Our ref: NO/2012/104337/01-L01
Your ref: 3/2012/0790
Date: 05 October 2012

**RETENTION OF STABLE BLOCK WITH COVERED MIDDEN AND
CONSTRUCTION OF AN OUTDOOR ARENA FOR USE AS A COMMERCIAL
LIVERY
GAME KEEPERS COTTAGE, PARK ROAD, GISBURN, LANCASHIRE, BB7 4LP**

SITE PLAN

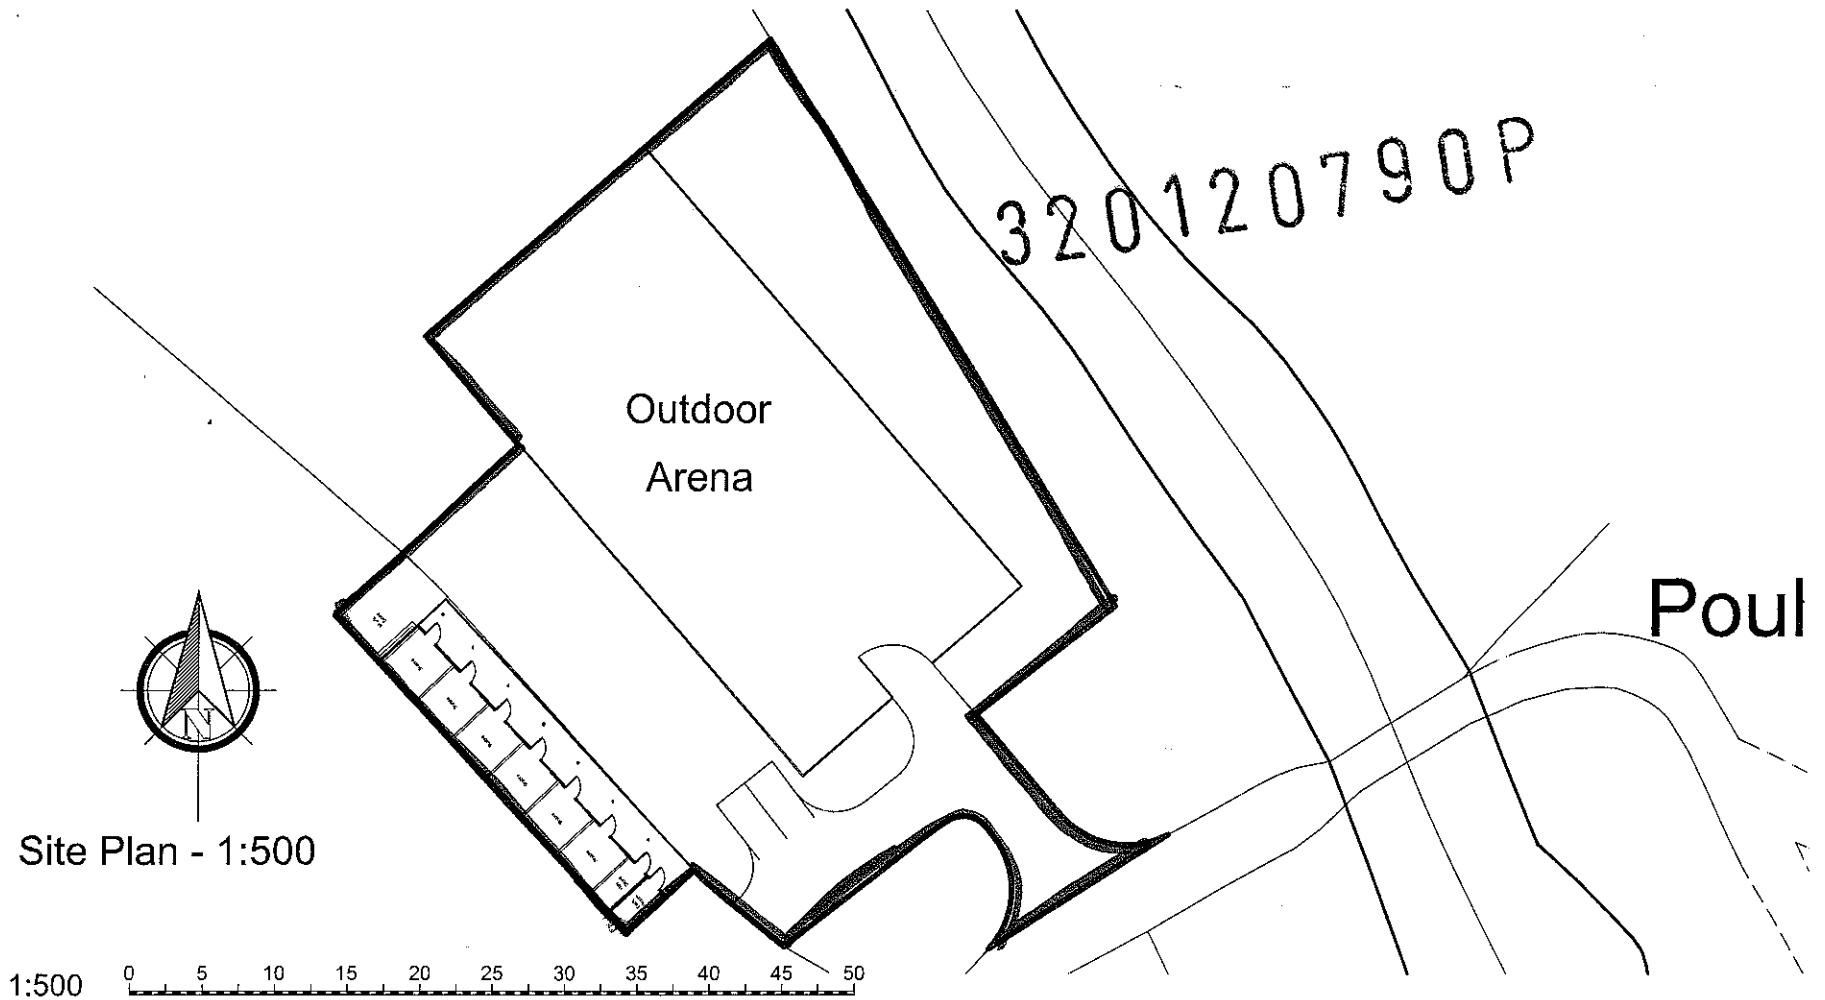
The development will be acceptable if a planning condition is included requiring the scheme to protect an 8 metre wide buffer zone around the watercourse.

Land alongside watercourses are particularly valuable for wildlife and it is essential this is protected. The provision and management of an 8 metre wide buffer zone alongside the watercourse shall be retained. The buffer zone shall be free from built development including lighting, domestic gardens and formal landscaping; and could form a vital part of green infrastructure provision.

Stock Beck adjoining the site is a designated Main River and is therefore subject to Land Drainage Byelaws. In particular, no trees or shrubs may be planted, nor fences, buildings, pipelines or any other structure erected within 8 metres of the top of any bank of the watercourse without prior written Consent of the Environment Agency. Full details of such works, together with details of any proposed new surface water outfalls, which should be constructed entirely within the bank profile, must be submitted to us for consideration.
